# CITY OF ALBUQUERQUE

February 5, 2016

**Re: Gorman Industries, Warehouse Addition**  
**1330 12<sup>th</sup> St., NW**  
**Request for Certificate of Occupancy- Transportation Development**  
Engineer's/Architect's Stamp dated 12-1-14 (J13-D100)  
Certification dated 1-13-16

EXISTING SITE PLAN

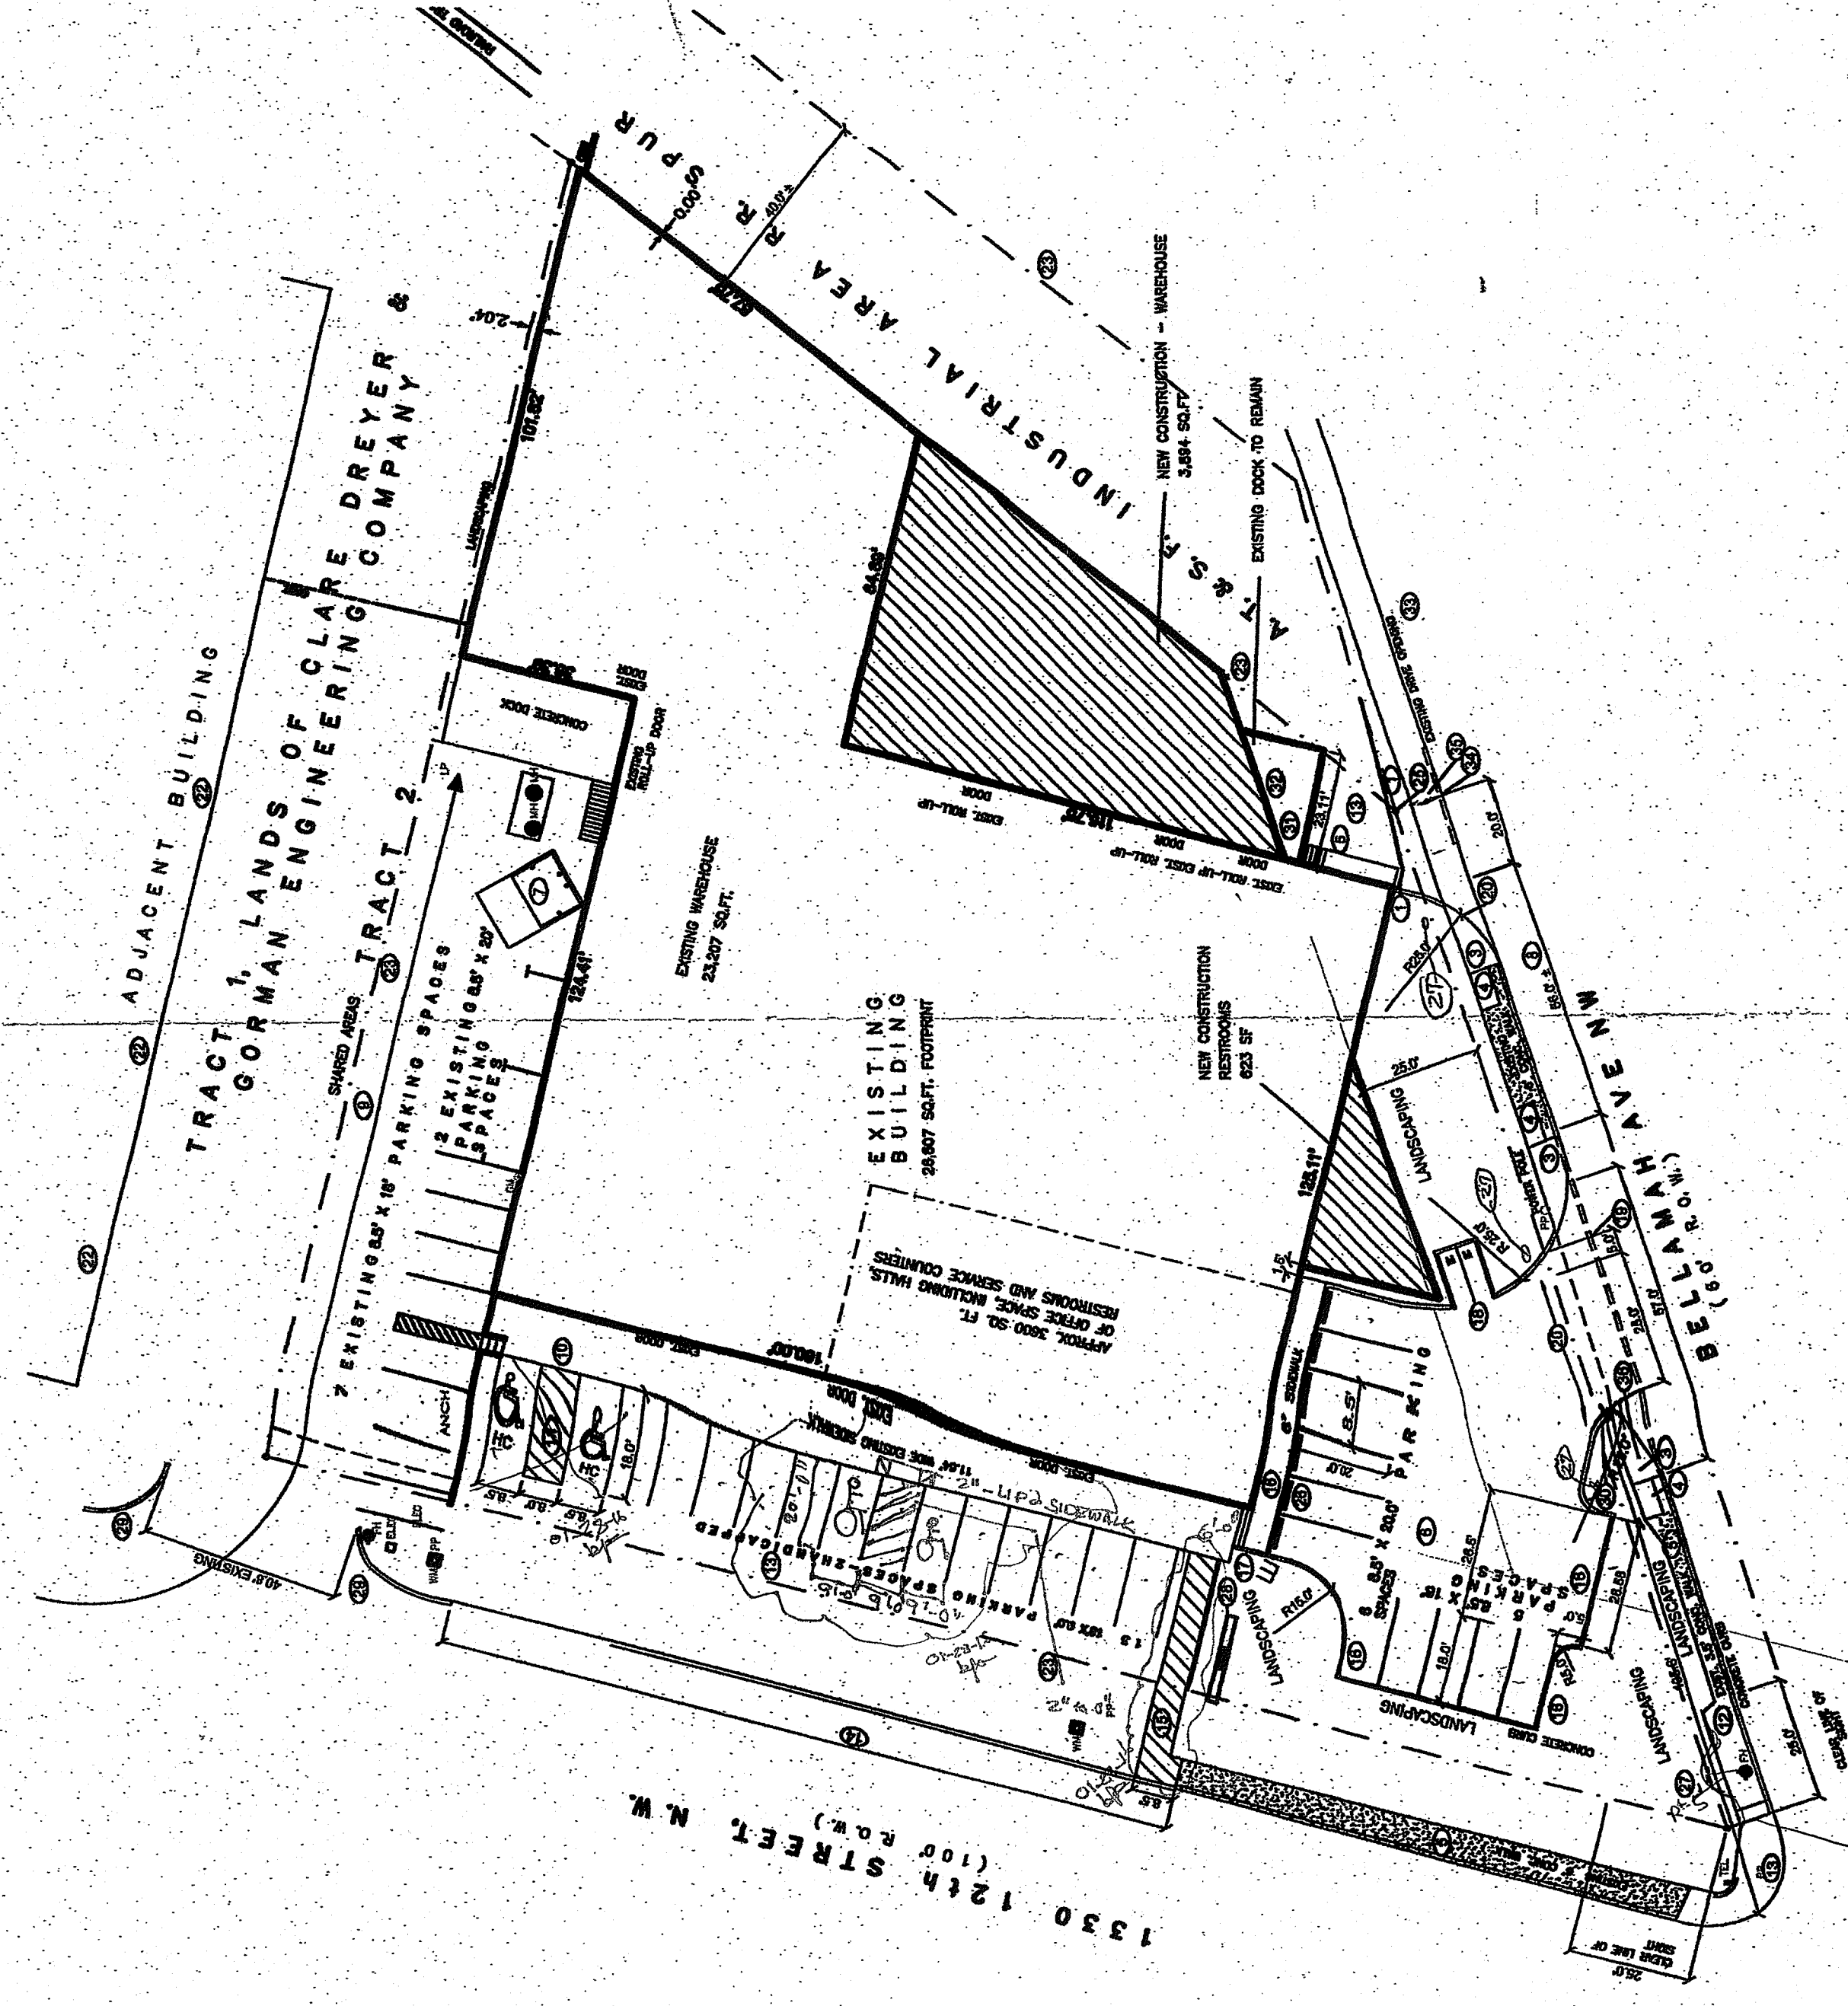
- ADA sidewalk at the south west corner of the project site at the fire hydrant must be reconstructed in accordance to COA standard drawing #2431.
- An easement must be created for the encroachment of a public right-of-way onto the projects property at the fire hydrant location.
